Subject: RE: A/168/21/PL - Land south of Littlehampton Road

Sorry for the delay in response and thank you for sending this over. This is insufficient to remove our holding objection.

Drainage Engineer

Preliminary Drainage Strategy

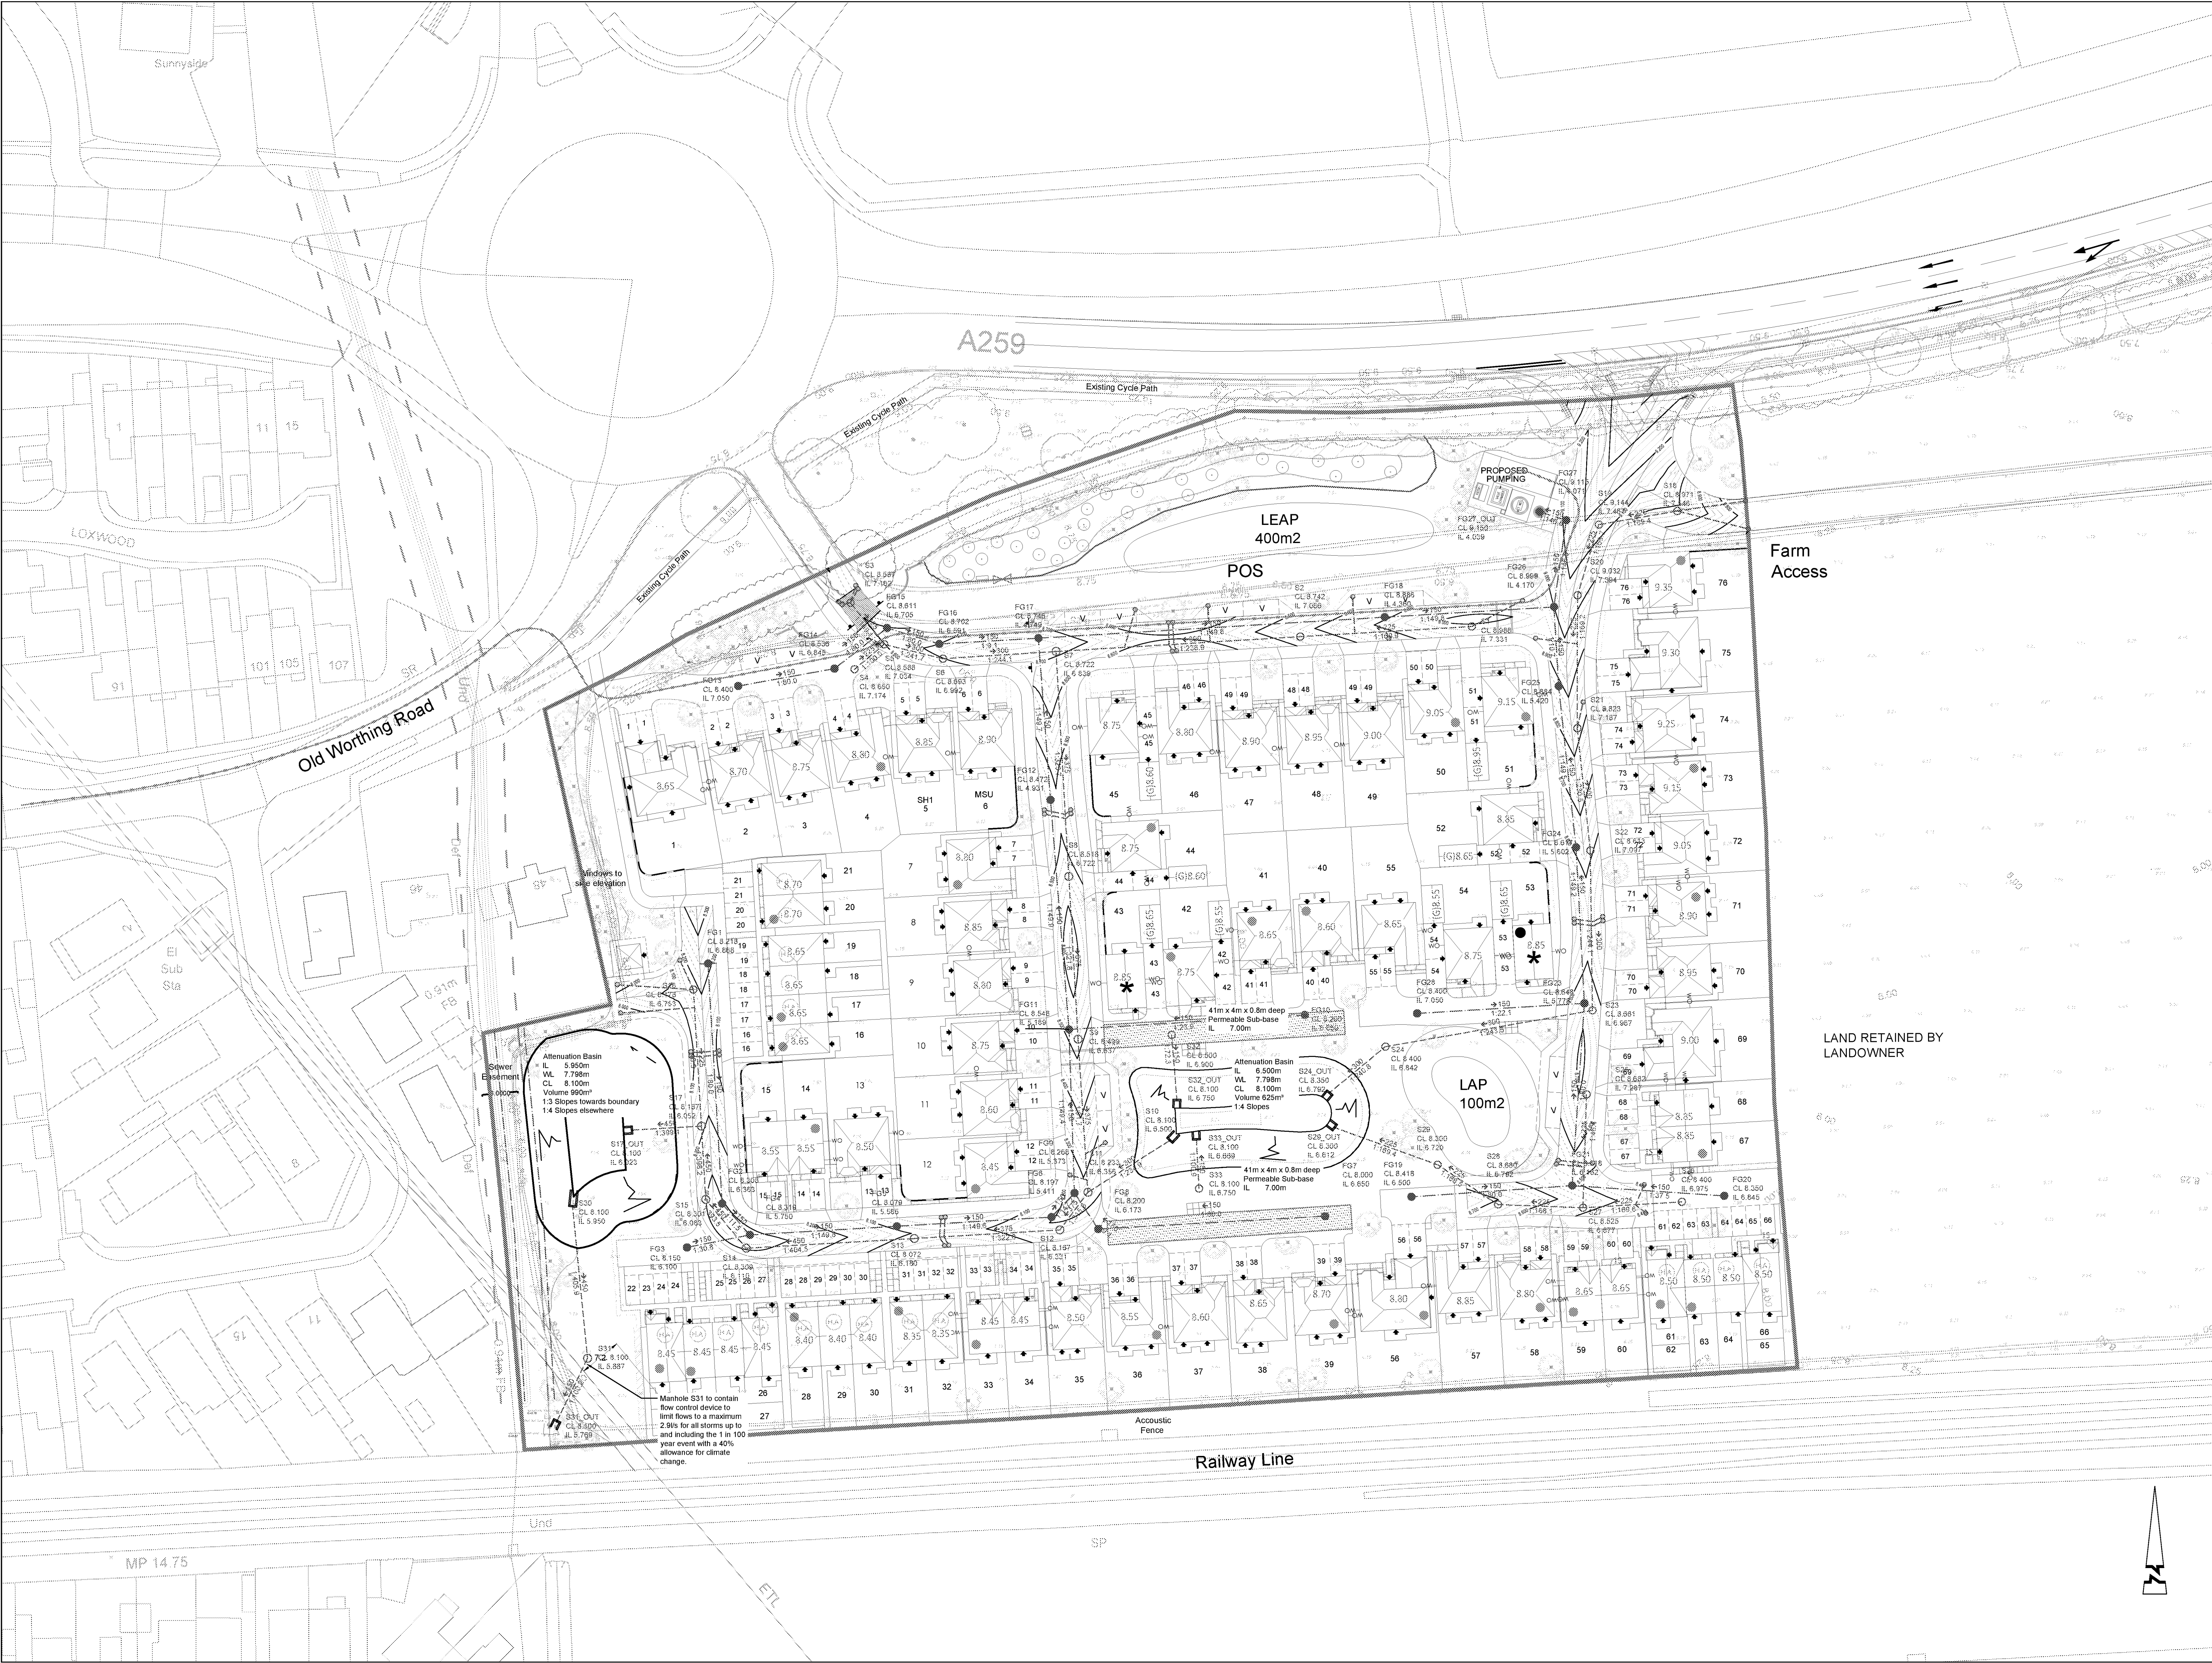
The applicant needs to submit details of an infiltrating scheme. I.e. one which utilises permeable paving throughout, e.g. all driveways and roads. We do not require freeboard between peak recorded groundwater level and the base of infiltrating structures, just that the base of structures is above peak groundwater level.

If infiltrating areas are kept local to source then impermeable areas which these areas serve can be kept low, along with the required factor of safety. Furthermore, driveways etc. can receive and infiltrate water which directly falls upon them without having to be 5m away from buildings. The applicant must look at drainage as a priority, rather than trying to fit drainage in around the layout and other constraints.

We require substantive calculations to evidence whether infiltration can be used more.
